Re: Falcon Self Storage and U-Haul Minor Subdivision
File #: MS232
Part of the NW ¼ SW ¼ of Sec. 1, Twp. 13 South, Rng. 65 West, 6th P.M.
Water Division 2, Water District 10
Upper Black Squirrel Creek Designated Basin
CDWR Assigned Referral No. 31194

We have reviewed the referral for a one lot minor subdivision to legalize a 5-acre parcel. The lot is used as an RV storage lot.

PCD PROJECT NO: PPR2232 & MS232

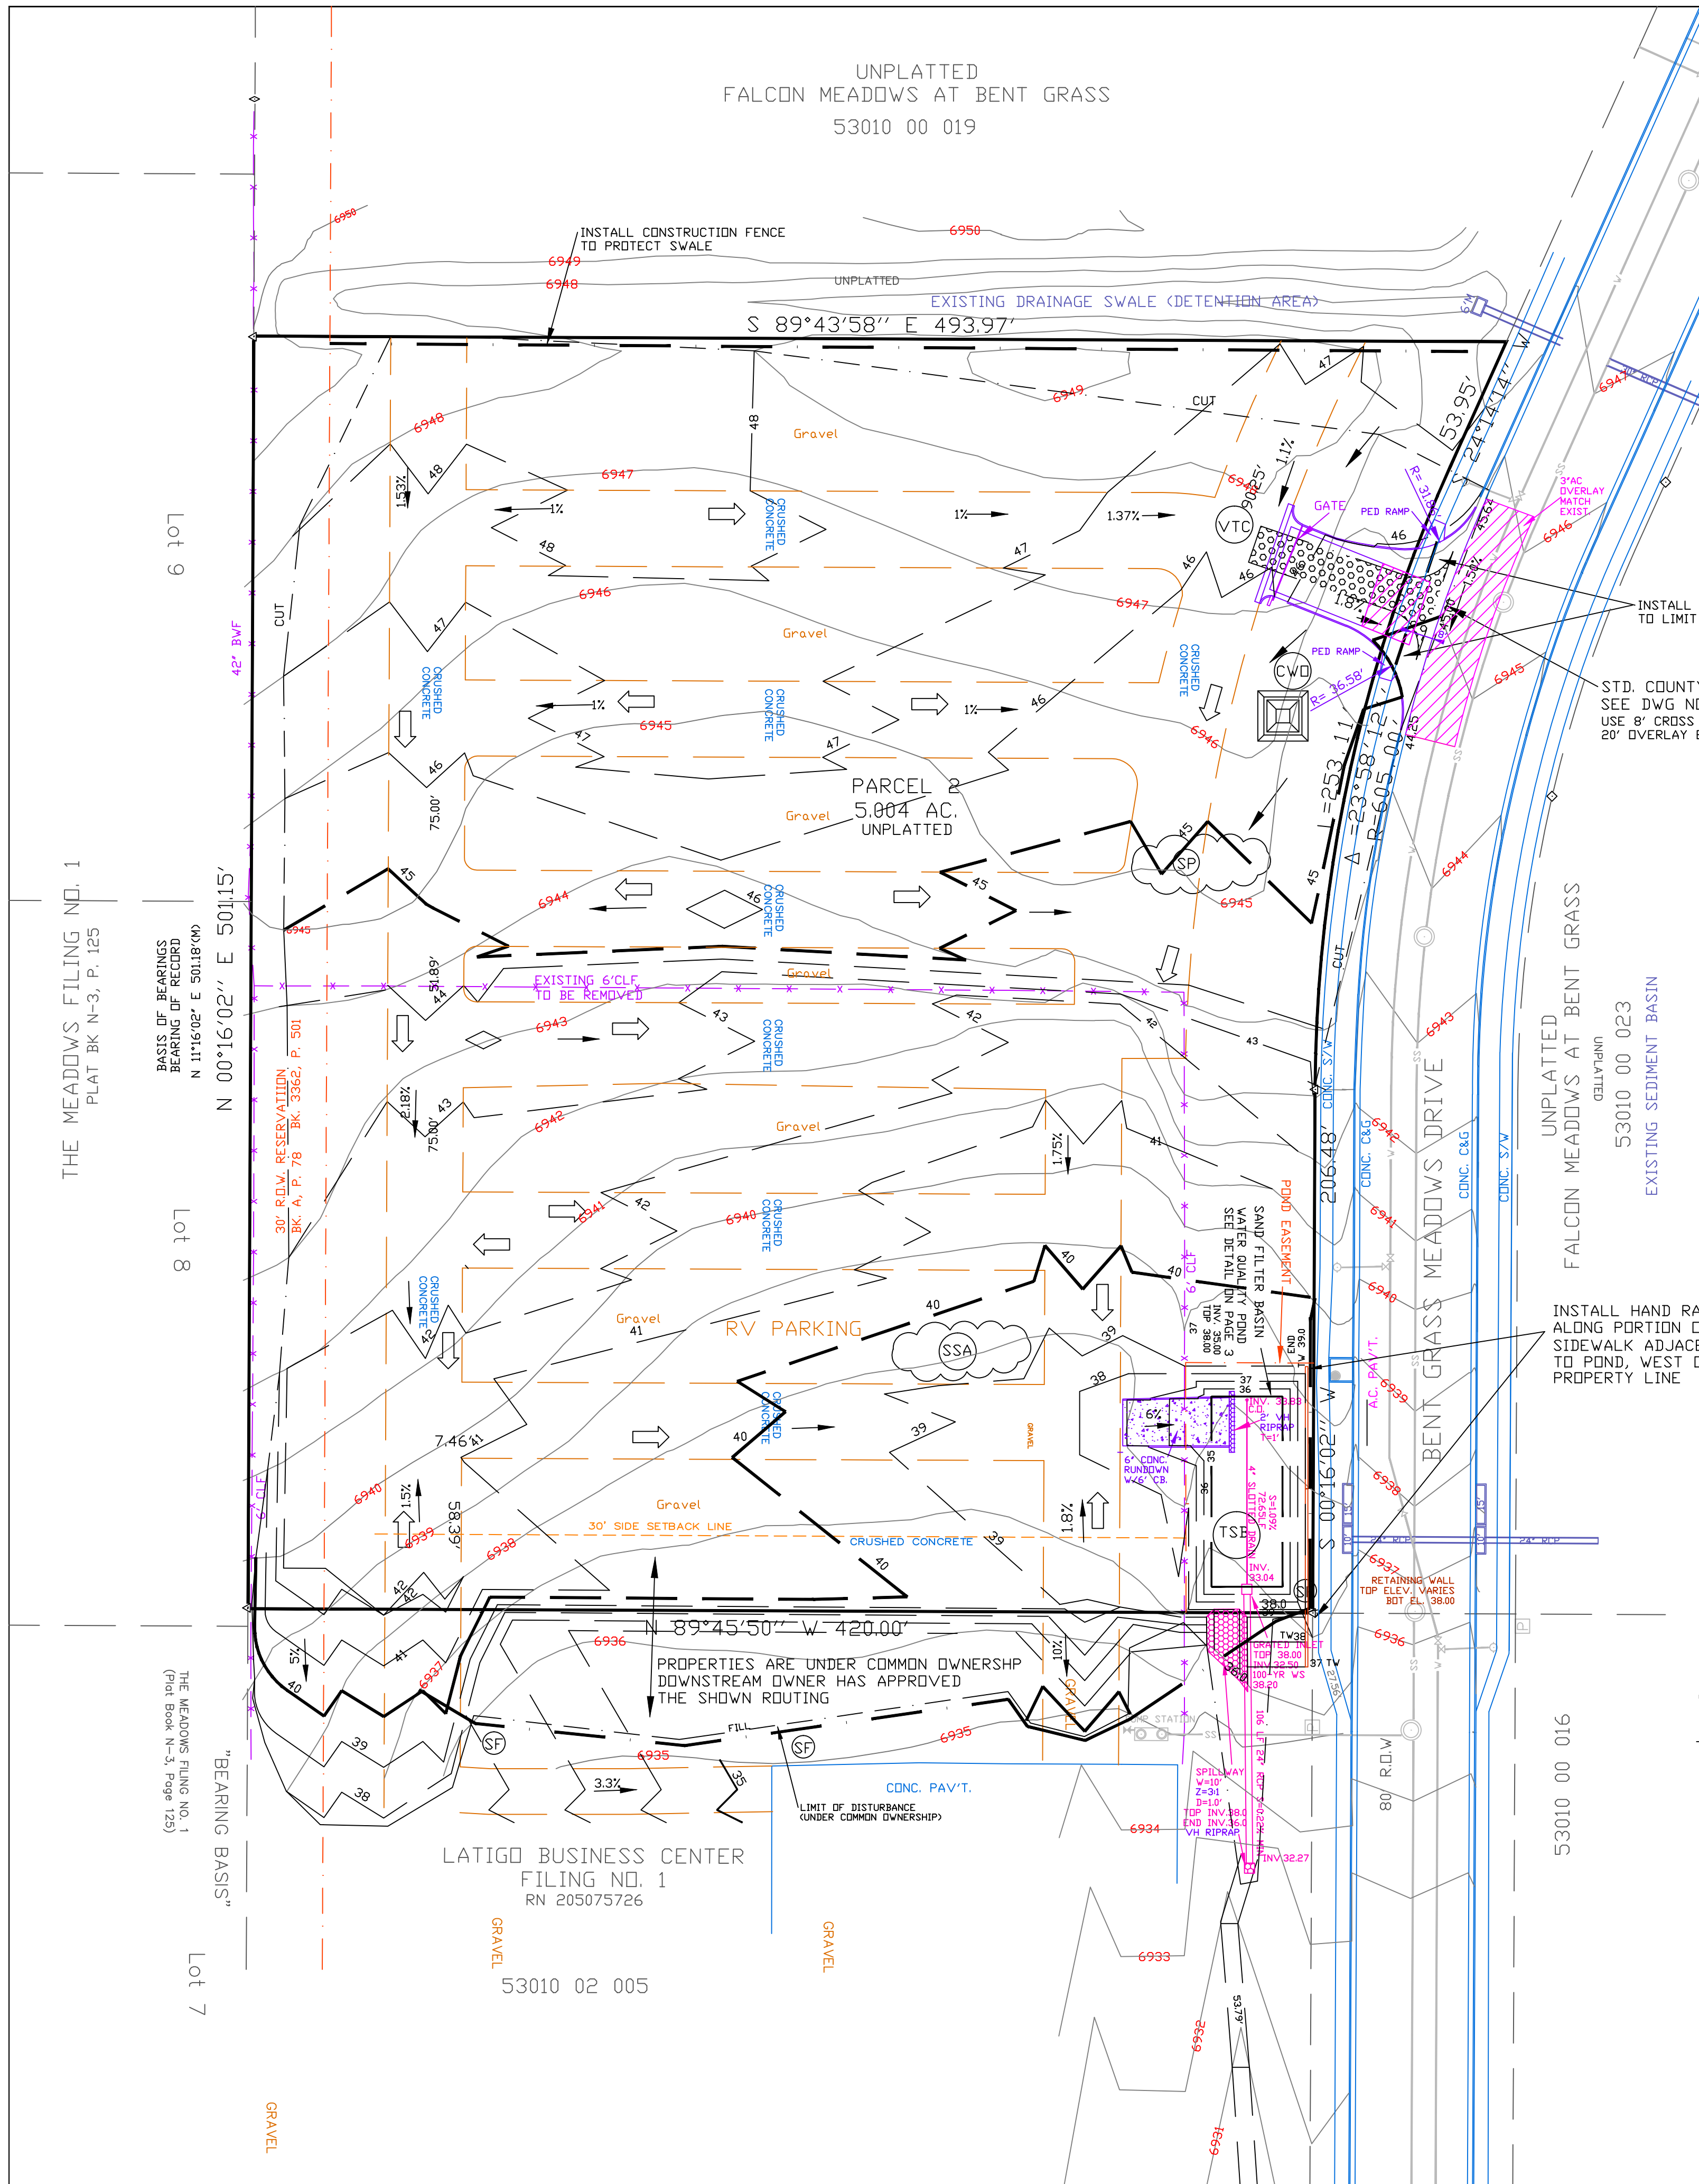
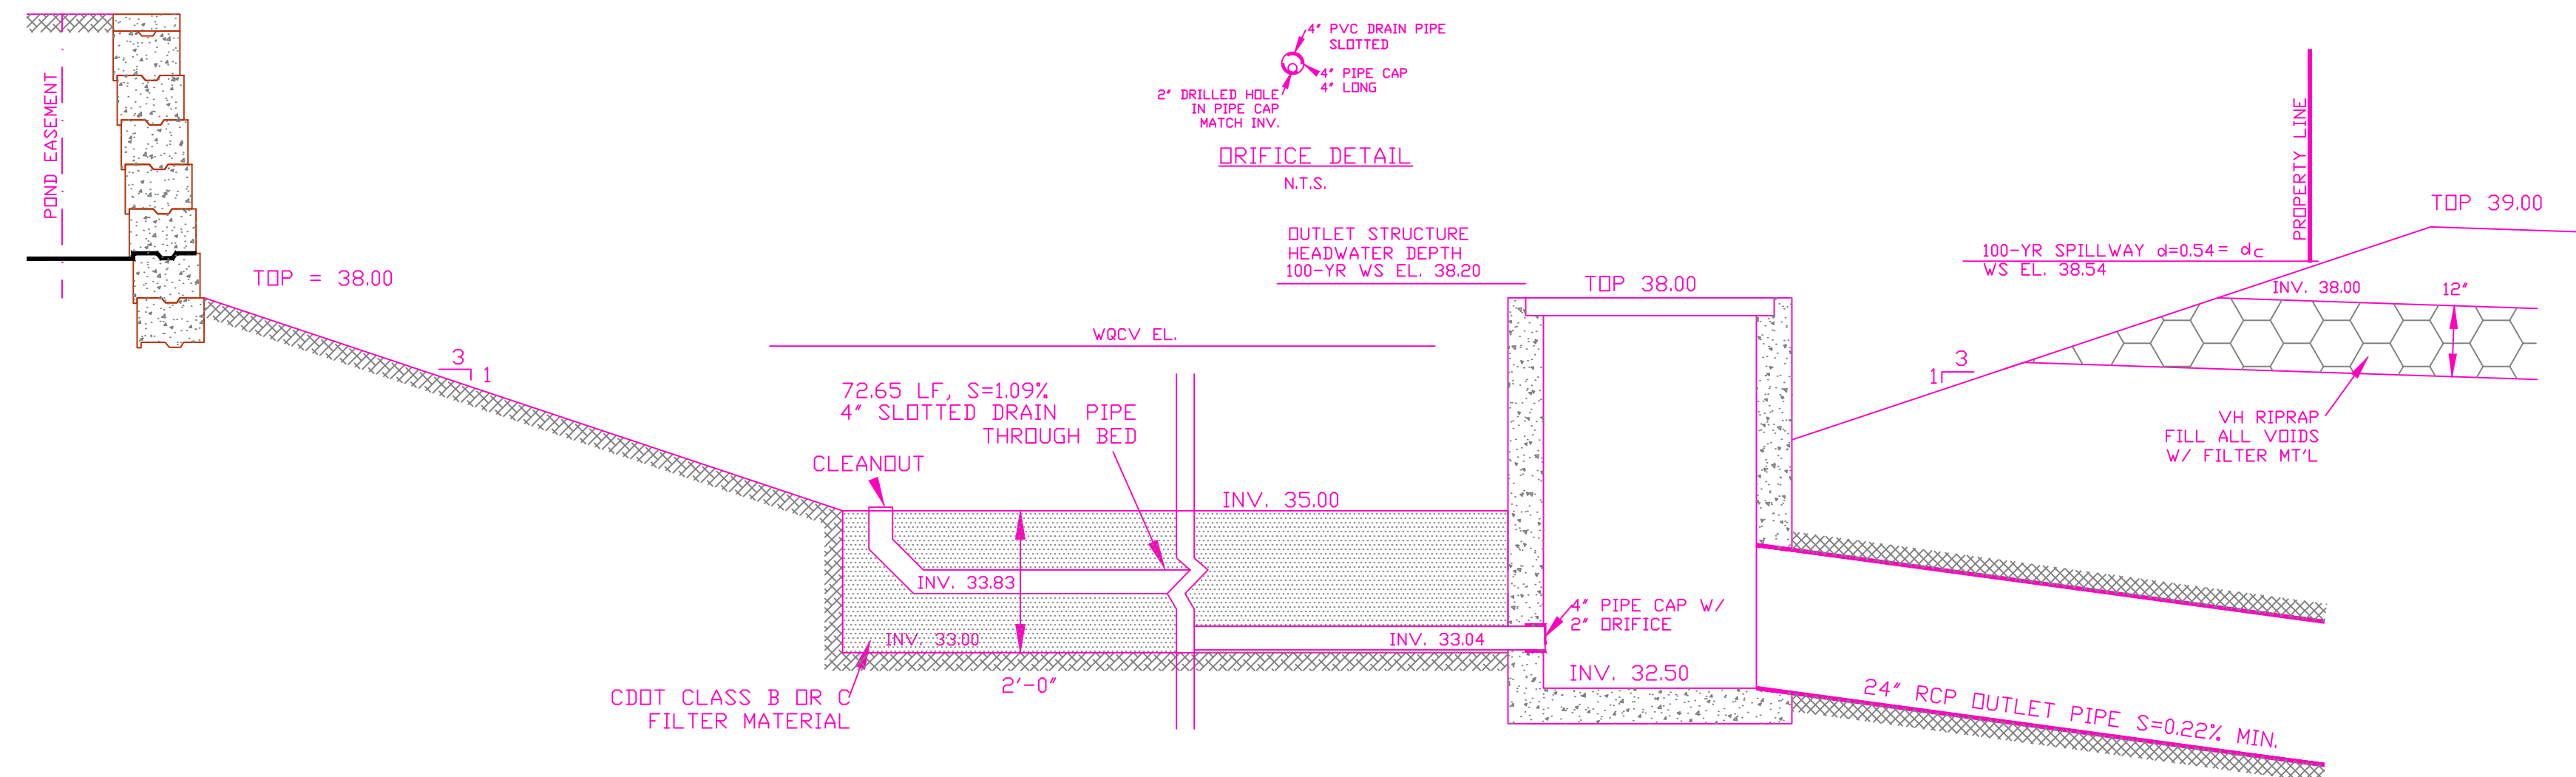
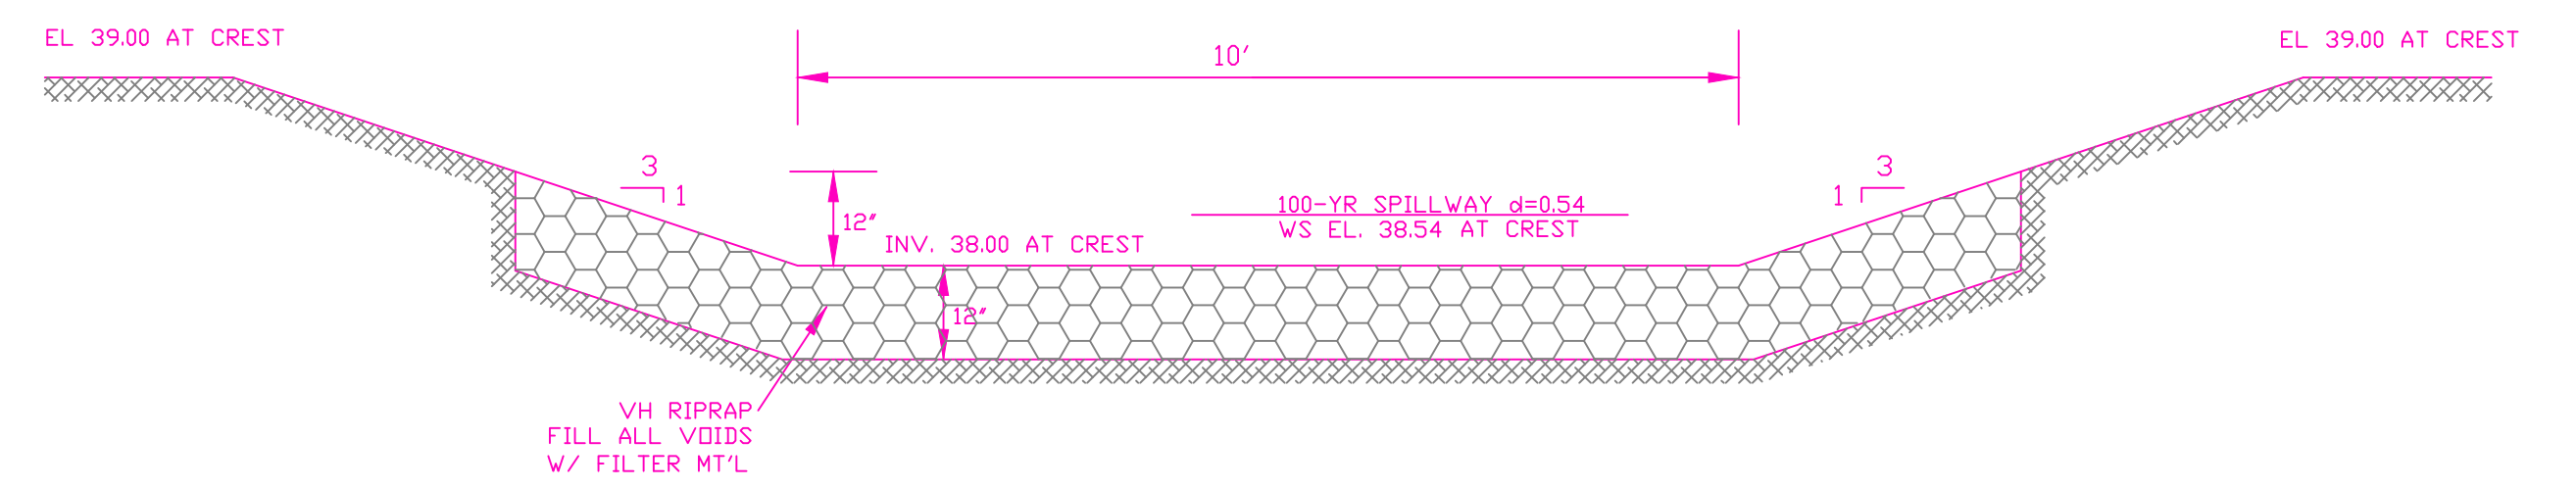
The submittal indicates that a stormwater detention structure is a part of this project. The Applicant should be aware that, unless the structure can meet the requirements of a “storm water detention and infiltration facility” as defined in Designated Basin Rule 5.11, the structure may be subject to administration by this office. The Applicant should review Rule 5.11 to determine whether the structure meets the requirements of the Rule and ensure any notification requirement is met.
